Engineers Comments Regarding Surface Water Drainage

Application Reference:	FP/10/26/DOC	Reviewer Reference:	ADC/EXT5/AF
Planning Officer:	Daniel Vick	Date of Review:	27/07/2026
Site Name:	Land off Stanhorn Grove Felpham PO22 8FA		
Application Description:	Approval of details reserved by condition under FP/32/25/S73 relating to conditions 6 & 7 - drainage.		
Assessment Number:	3

Application Reference: FP/10/26/DOC Site Name: Land off Stanhorn Grove Felpham PO22 8FA	Initial Issue Date: 16/02/2026 Issue Date: 27/07/2026 Reviewer Reference: ADC/EXT5/AF
--	--

DRAWING TITLE
Drainage Layout

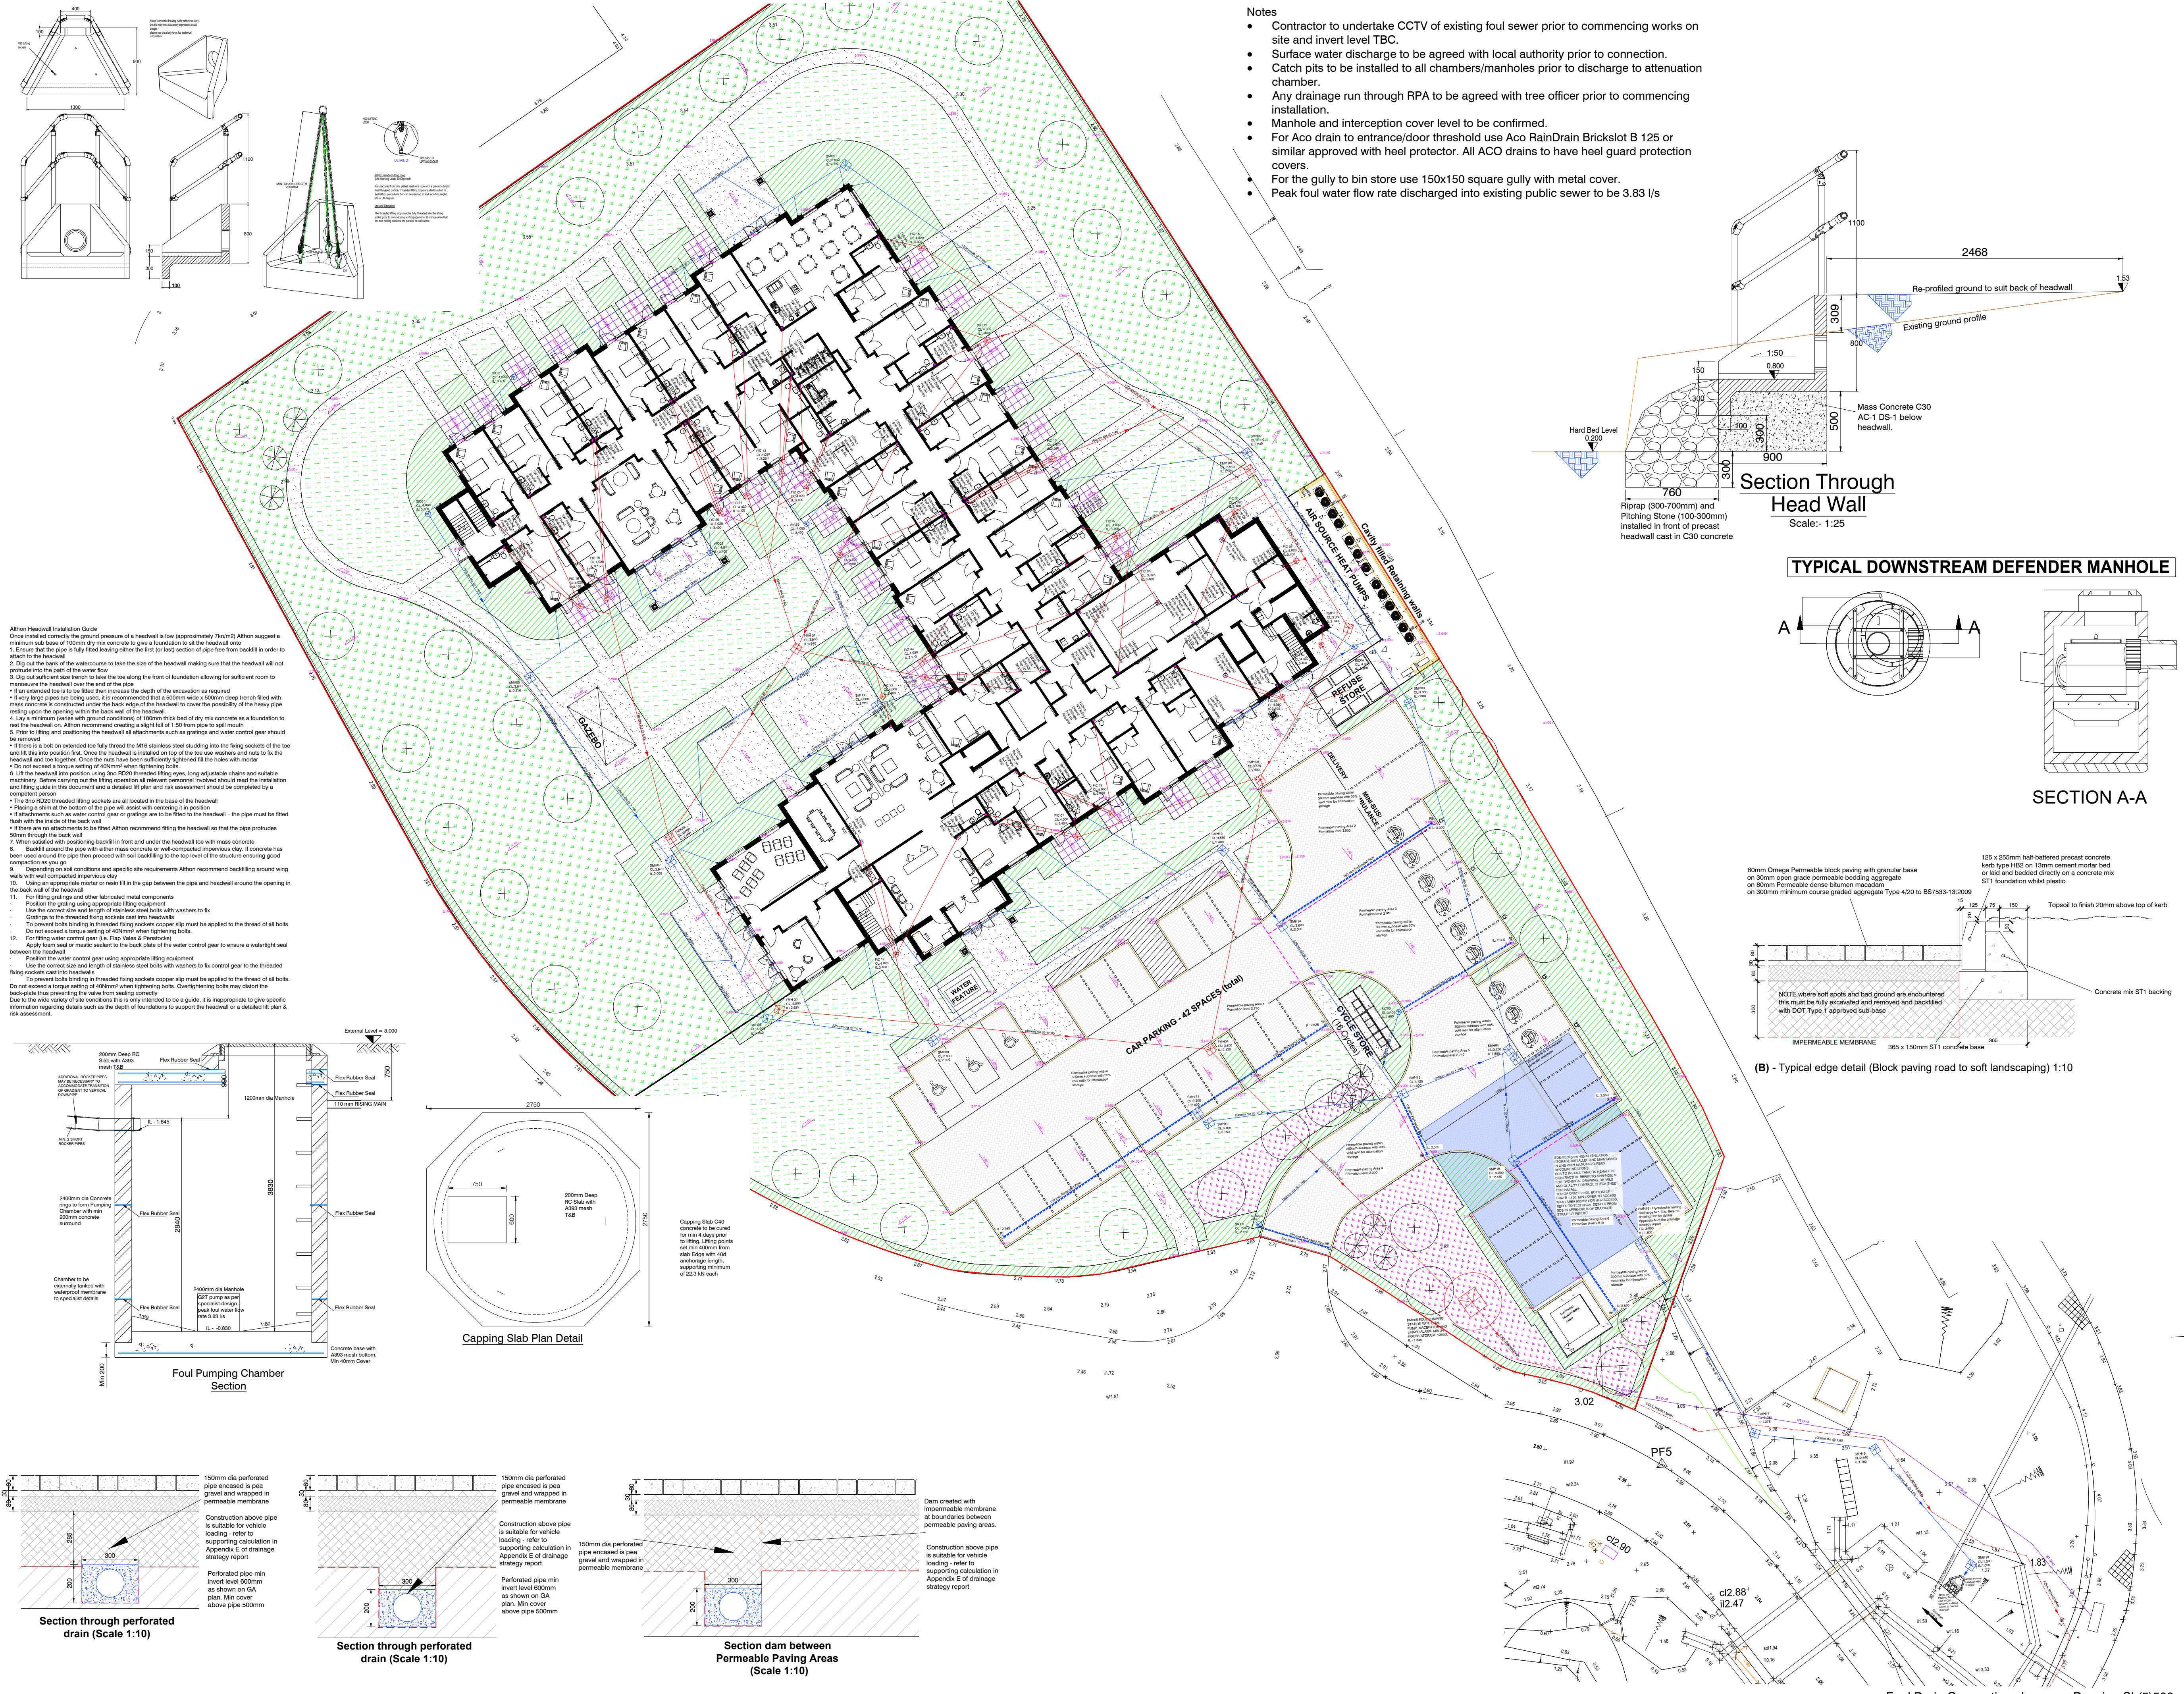
5. (Formerly 12)			Additional comment: There are a number of permeable paving compartments which are not physically segregated. They are not defined in plan and it is difficult to audit the areas. The overflow level in the plans appears to be 2.78m AOD. The modelled compartments all have higher exceedance level and fill to higher levels during the design storm, some clarification is required to confirm that the	None.	It is not clear how this comment has been addressed. Some commentary or response from the designer should be provided.

permeable paving would fill to the modelled levels without overtopping at the low point of the combined construction.		
6. (Formerly 13)			Additional comment: There are trees shown within the plan area of the crate storage installation. The coordinated design needs to be confirmed to ensure trees will not damage the installation.	None.	Comment closed.
Condition Number: 7

JOB NO.	DWG NO.	REV
0043	SL(5)503	A

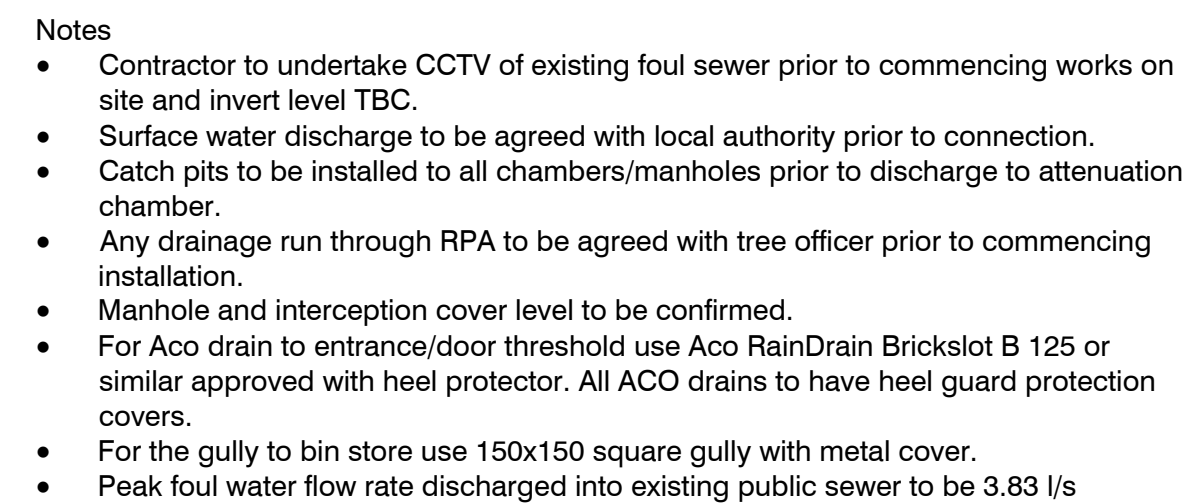
Comment Number					
1. (Formerly 3)	Construction details should be provided for all drainage elements including the permeable surface paving and the soakaway. Designer Response 30/01/2026 (FP/181/25/DOC) See updated drawings I Appendix F	A construction detail should be provided for the flow control chamber.	A detail is provided but it does not appear to comply with the recommendations of the flow control device manufacturer. This should be checked and updated. There is also a concern that the crate installation detail does not contain sufficient detail to guarantee watertight construction. This is essential as it is below the high	None.	The details within revision D of the Drainage statement dated 26 June appear unchanged. Repeat comment: A detail is provided but it does not appear to comply with the recommendations of the flow control device manufacturer. This should be checked and updated. There is also a concern that the crate installation detail does not contain sufficient detail to guarantee watertight construction.

groundwater level. The crate installation must be fully watertight with welded joints formed in an impermeable membrane protected from puncture and using watertight pipe connections. This is not clear from the detail provided. The perforated pipes within the permeable pavement appear to be shallow and unprotected and therefore susceptible to collapse under vehicle loading, the detail should be clarified.		This is essential as it is below the high groundwater level. The crate installation must be fully watertight with welded joints formed in an impermeable membrane protected from puncture and using watertight pipe connections. This is not clear from the detail provided. The perforated pipes within the permeable pavement appear to be shallow and unprotected and therefore susceptible to collapse under vehicle loading, the detail should be clarified.
